Pagham Parish Council
C C Braby
Village Hall
Pagham Road, Pagham
West Sussex
PO21 4NJ

28th July 2011

Single storey extensions
52 East Front Road Pagham

Thank you for your internet representation made on 27th July 2011 which has been recorded as **an objection** with the comments as follows:

For	Date	Dwg by	Revision
Mr and Mrs Evers	24.05.2011	sk	C
Title	Scale	Project no	Dwg no
PROPOSED LAYOUT, ELEVATIONS AND SECTION A-A	1:50	126	P2

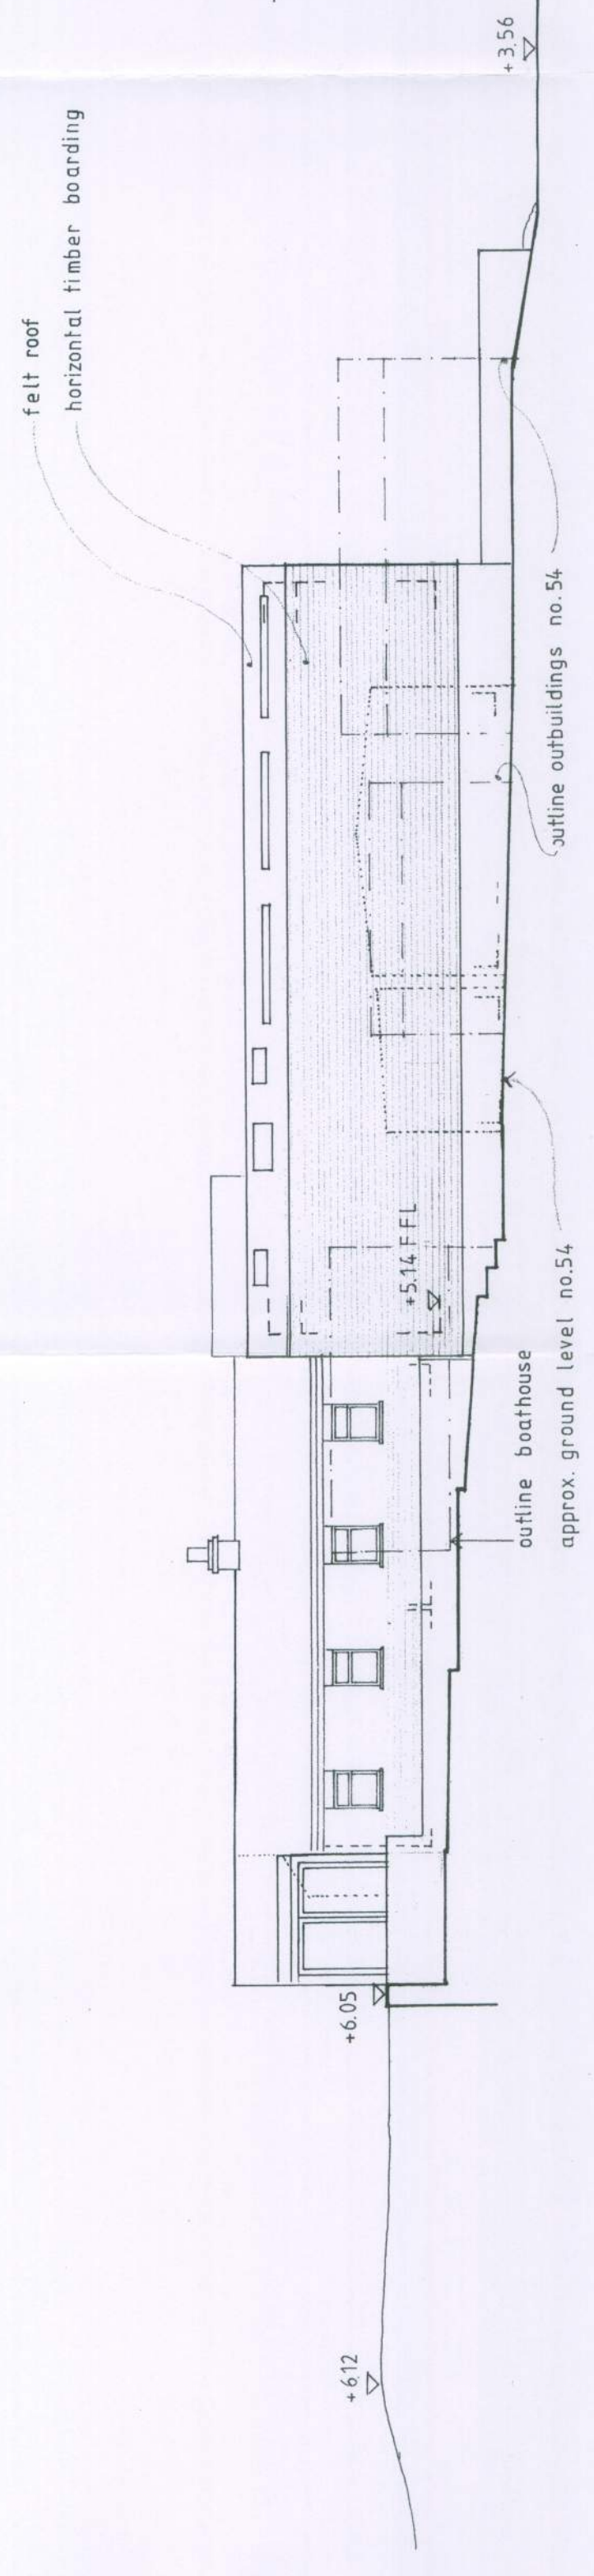
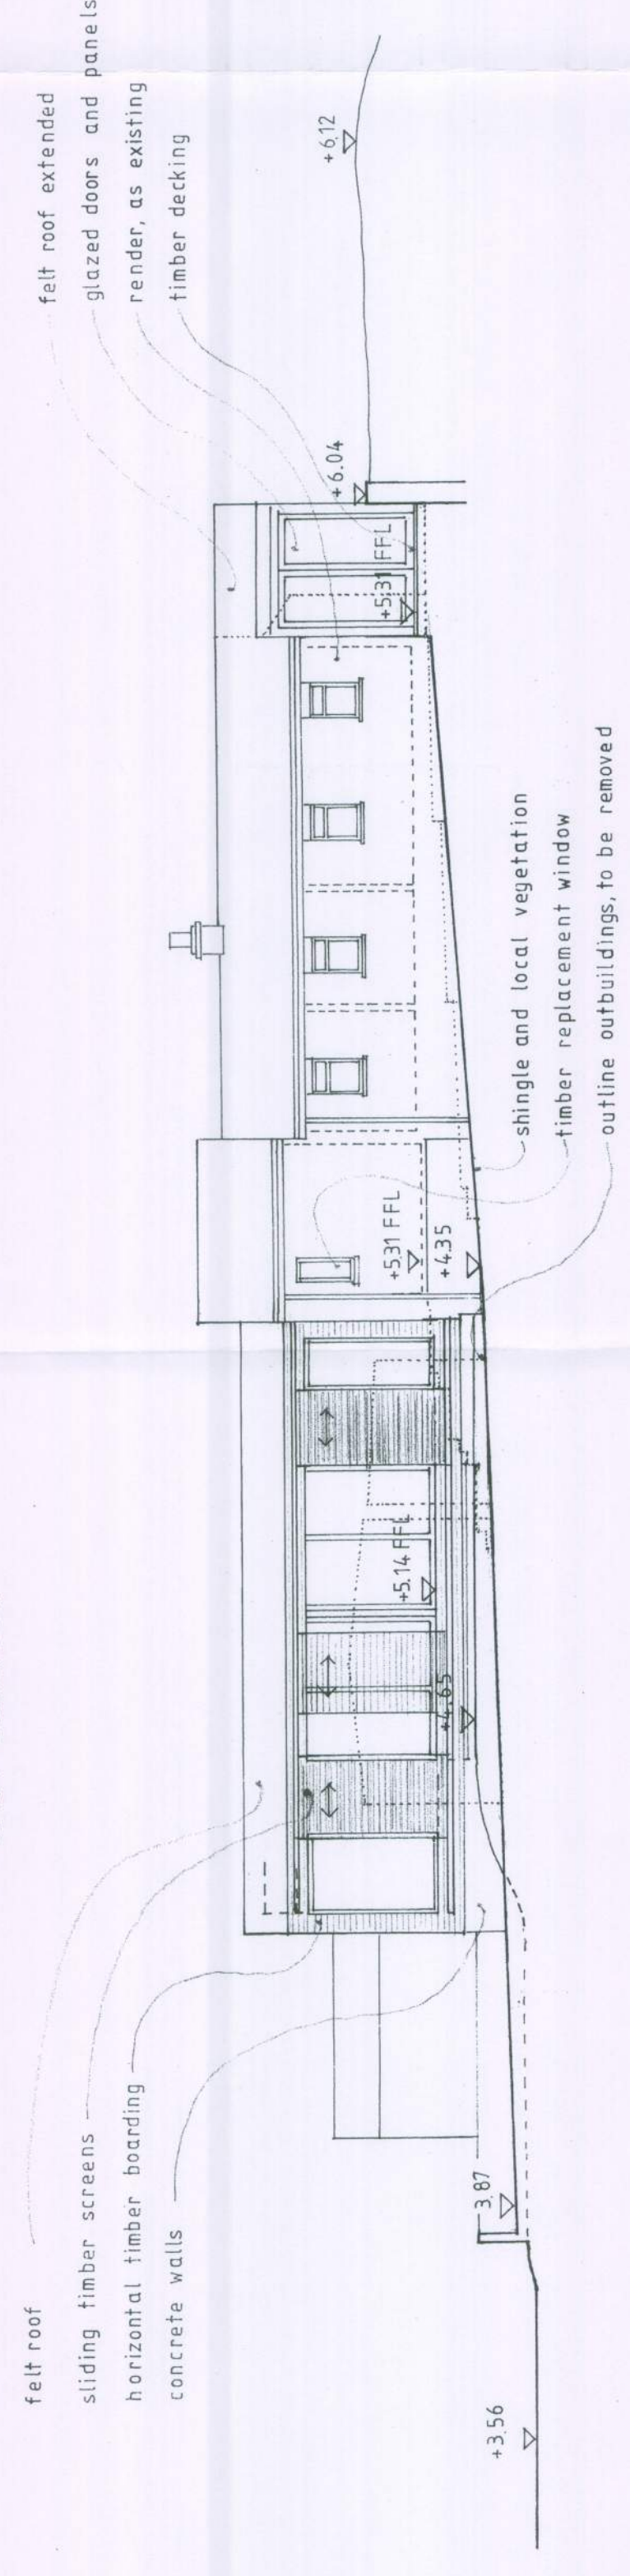
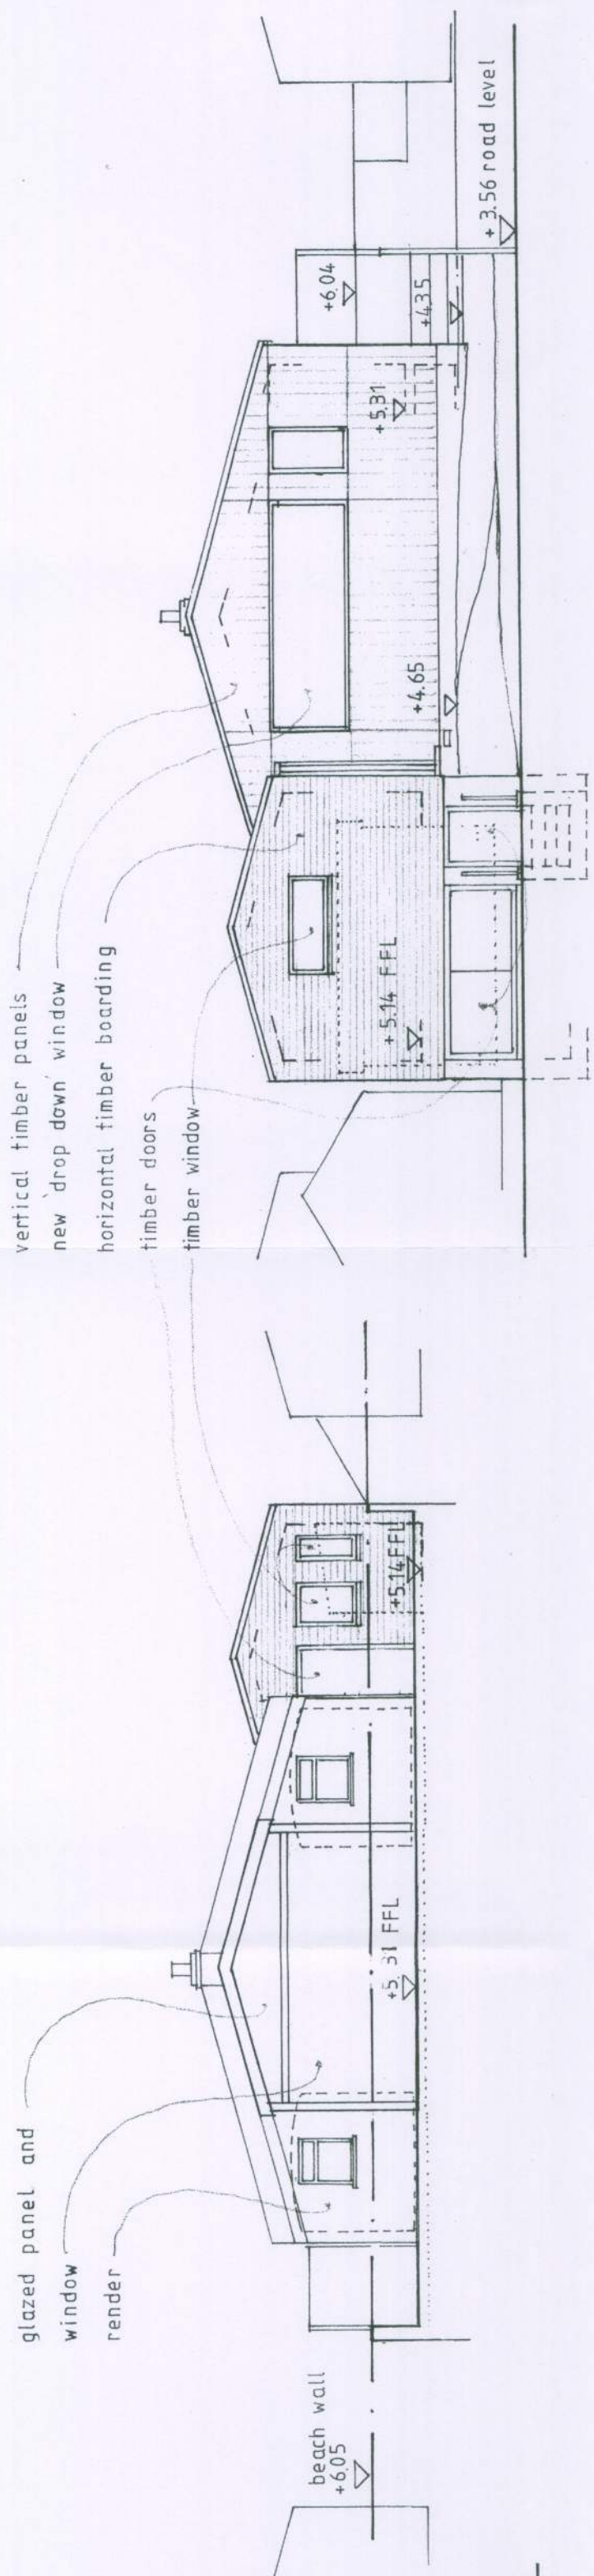
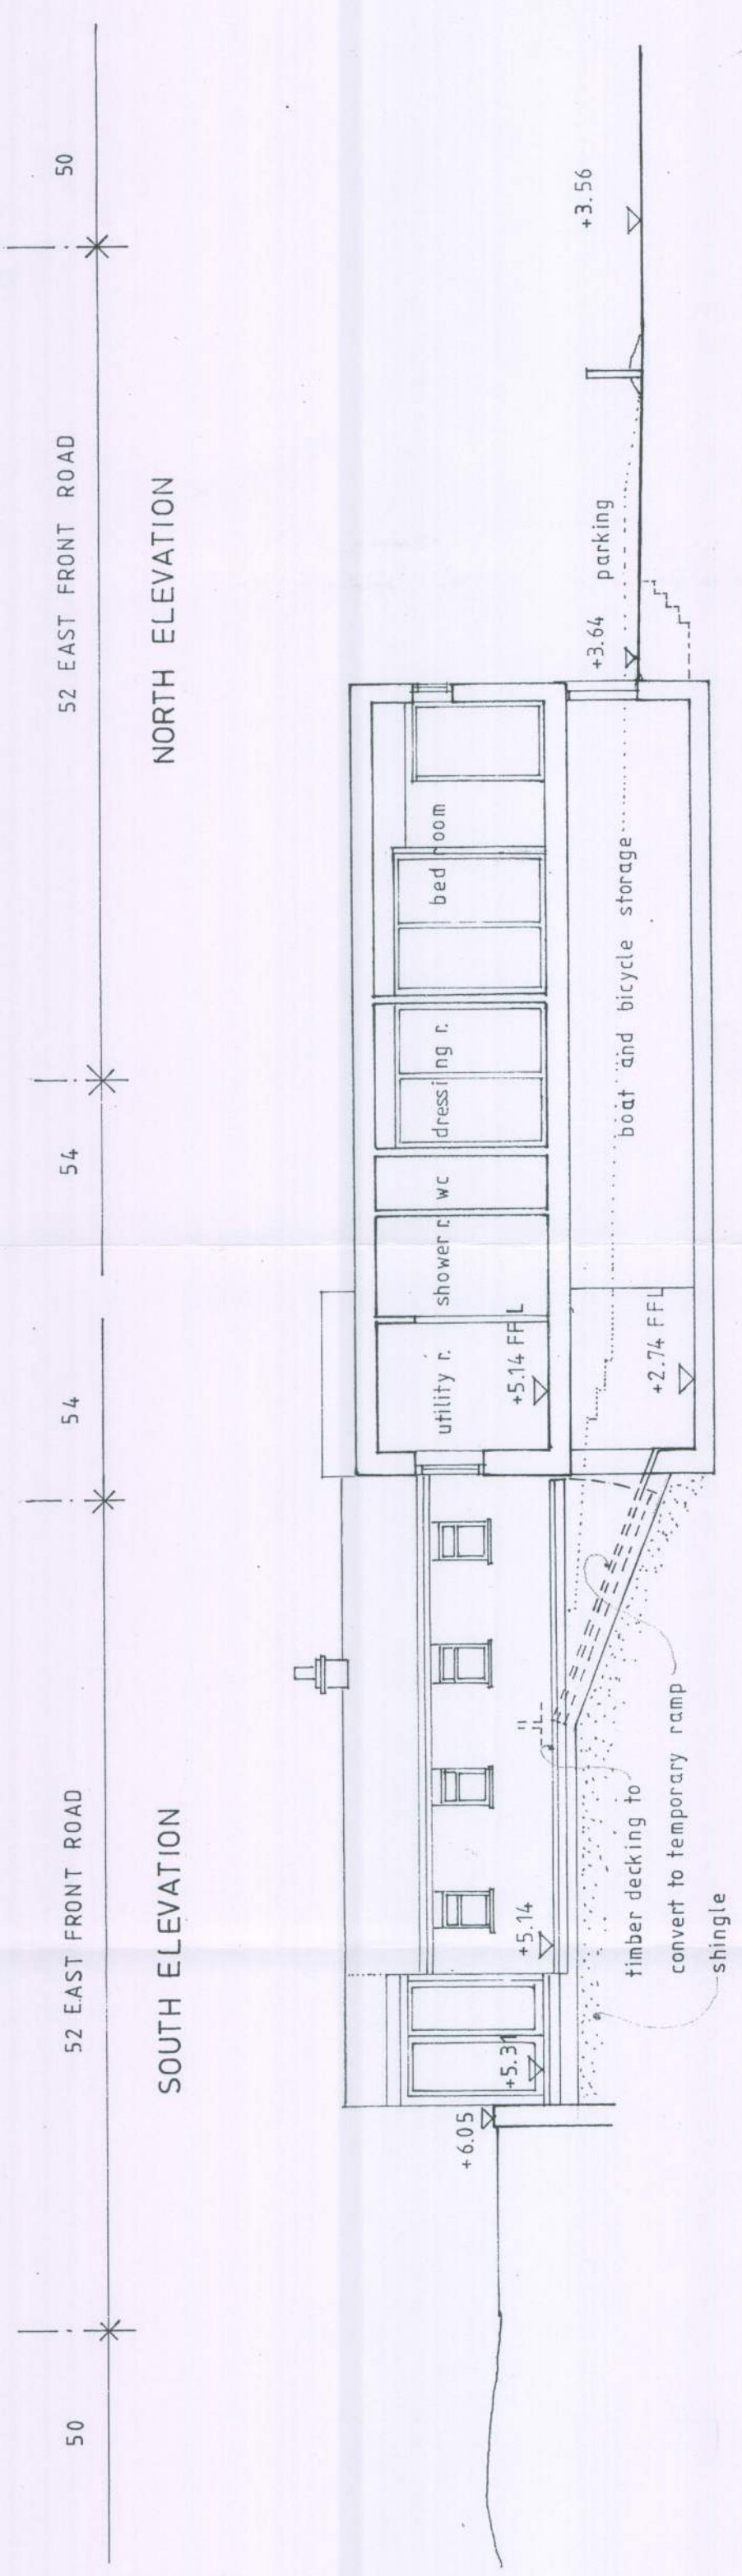
Members felt that this proposal warranted particular scrutiny as it purported to set a precedent for two storey development in respect of which there has been consistent adopted policy constraint since 1975. ☐

Representations from the public have also highlighted the out of character, intrusive and prejudicial nature of recent applications such as this which seek to establish maximum footprint and bulk with little regard to EA recommendations for drainage in a 3a flood zone. Members agreed with these representations that this proposal was dominant and overbearing to adjacent dwellings. ☐
